COMMUNITY SERVICES DEPARTMENT

June 24, 2019

Subject: Walden Preserve 2 Filing No. 4 Final Plat

DRAWING: 17094FP4.DWG PAGE 2 OF 2

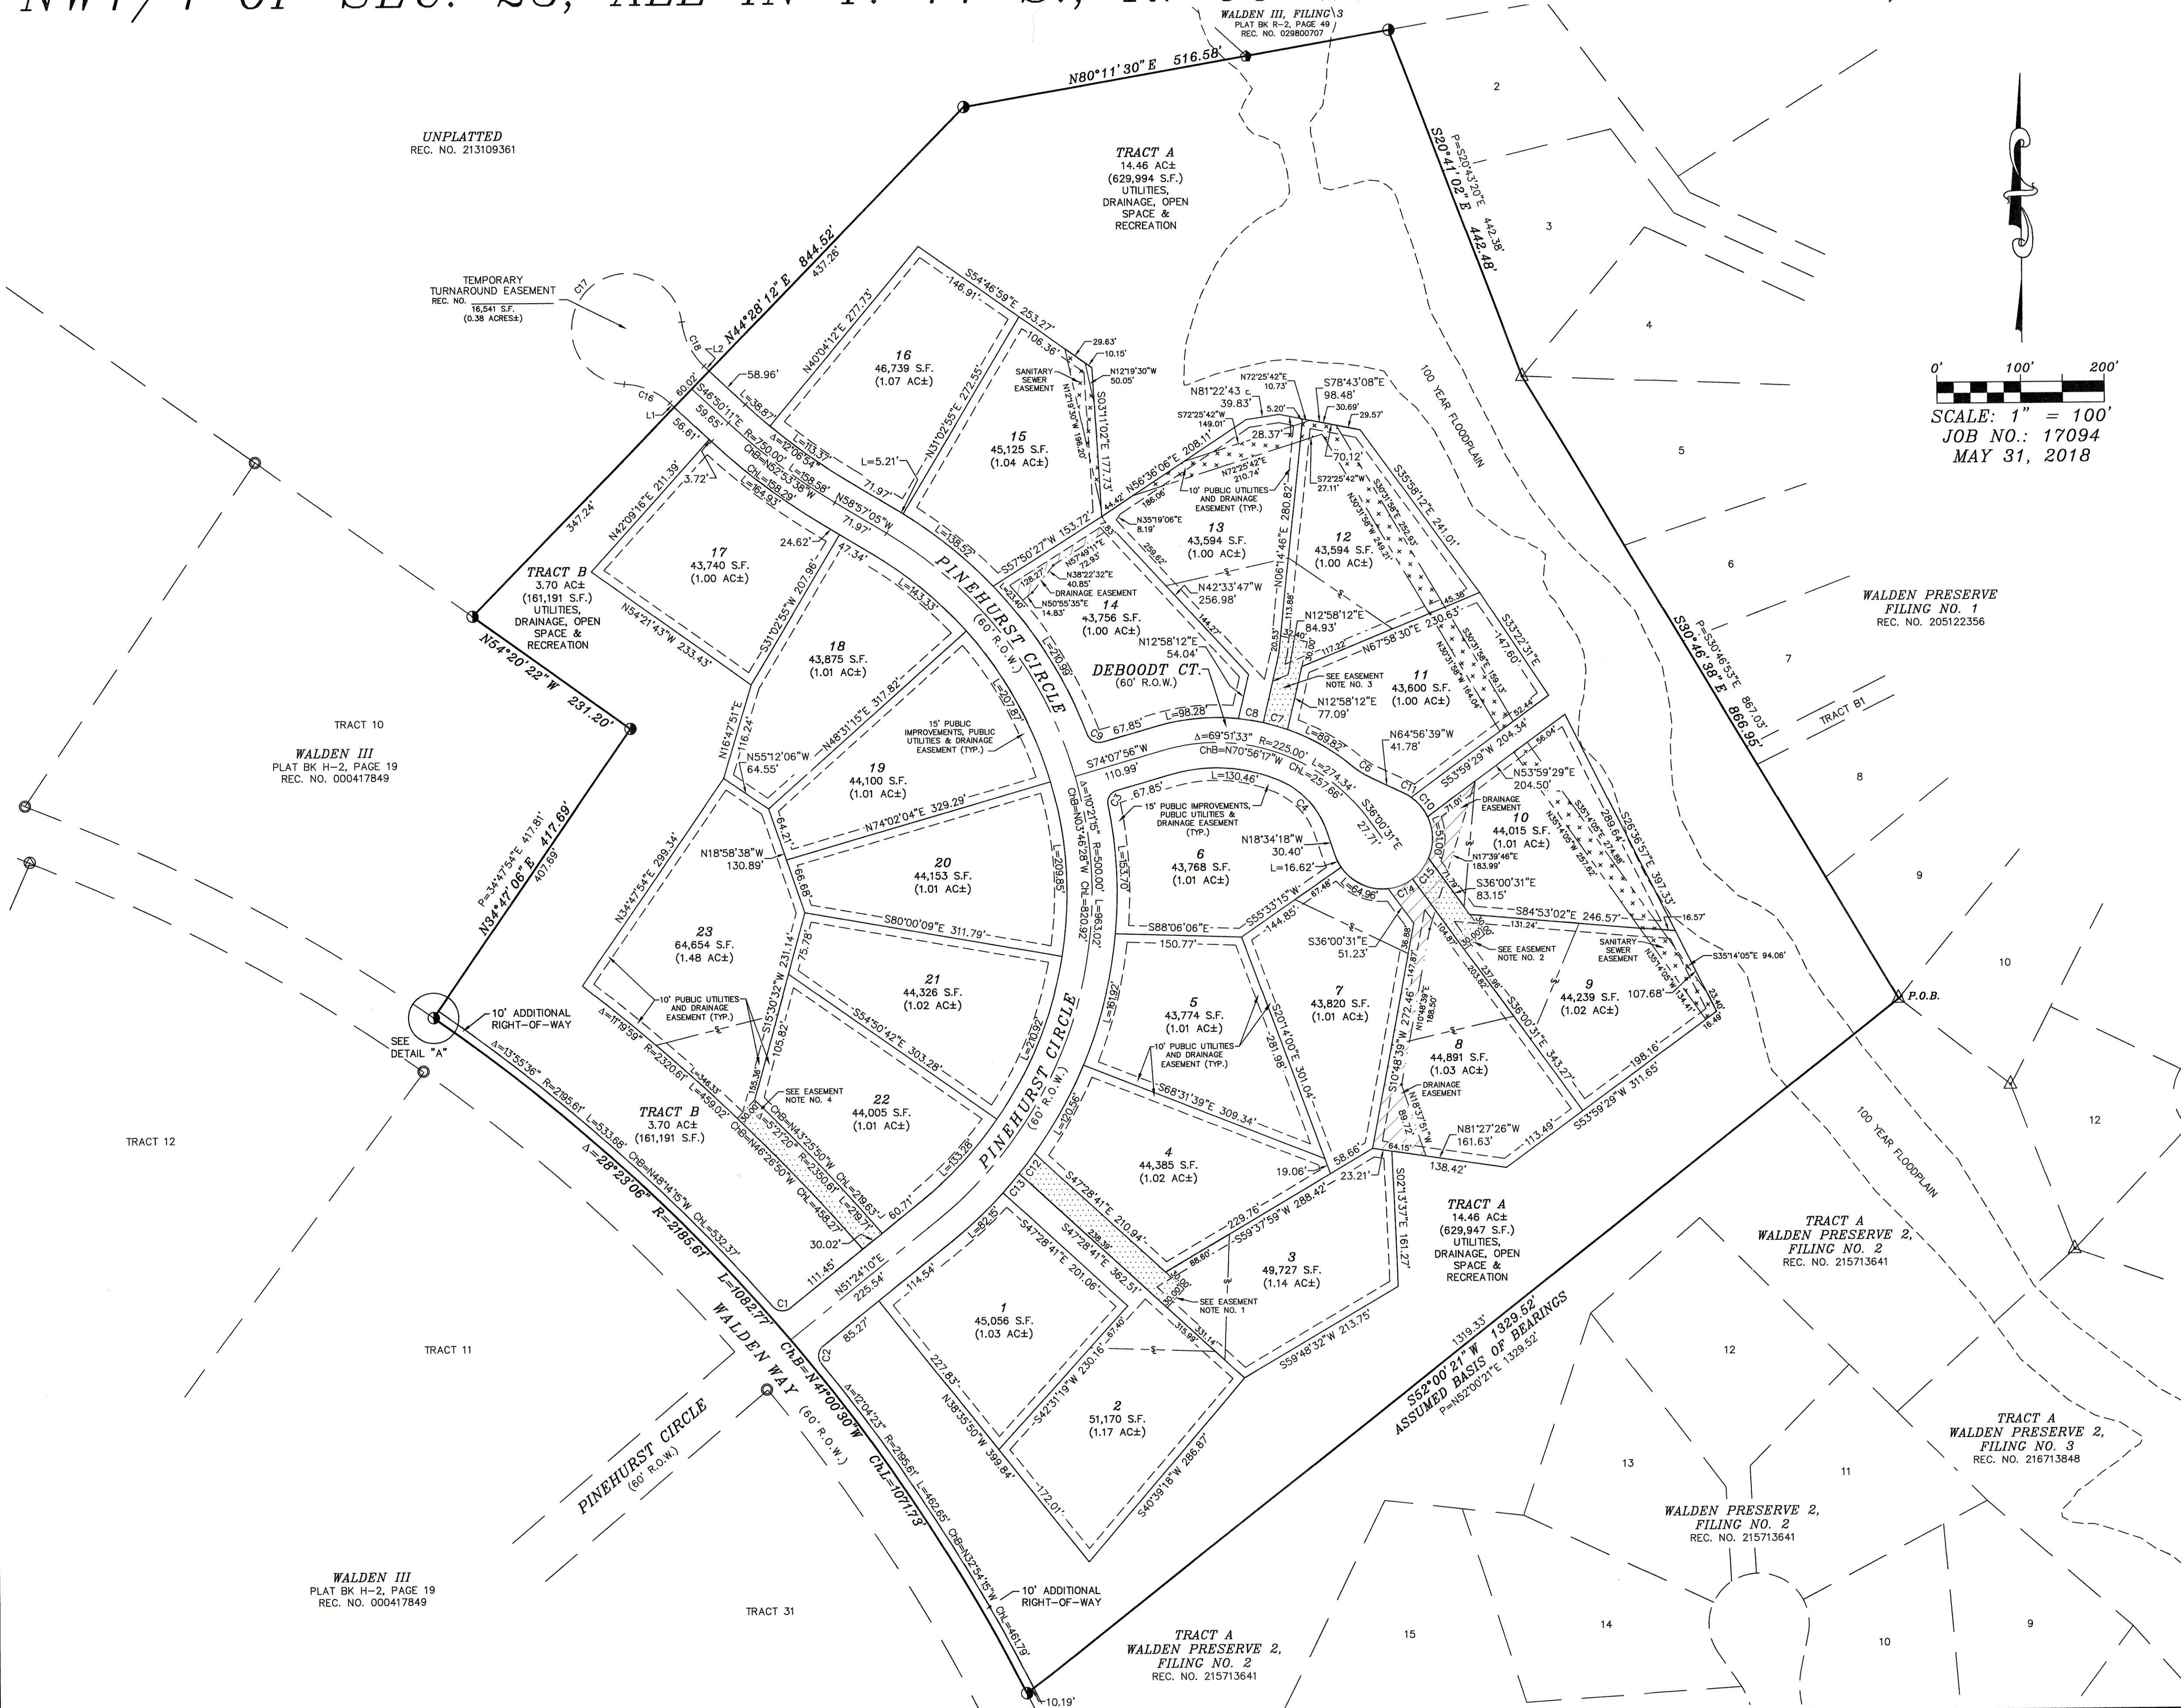
The El Paso County Parks Master Plan identifies the Cherry Creek Primary Regional Trail traversing through the Walden Preserve Subdivision. A trail easement was included on the previously approved preliminary plan drawings for the regional trail; however the easement is missing from the Filing No. 4 Final Plat drawings. Staff recommends the applicant show the 25 foot public trail easement on the final plat drawings within Tract A and Tract B, consistent with the previously approved Preliminary Plan and PUD drawings. Staff also recommends the applicant include a note on the final plat drawings allowing for public use and County access for construction and maintenance of the regional trail.
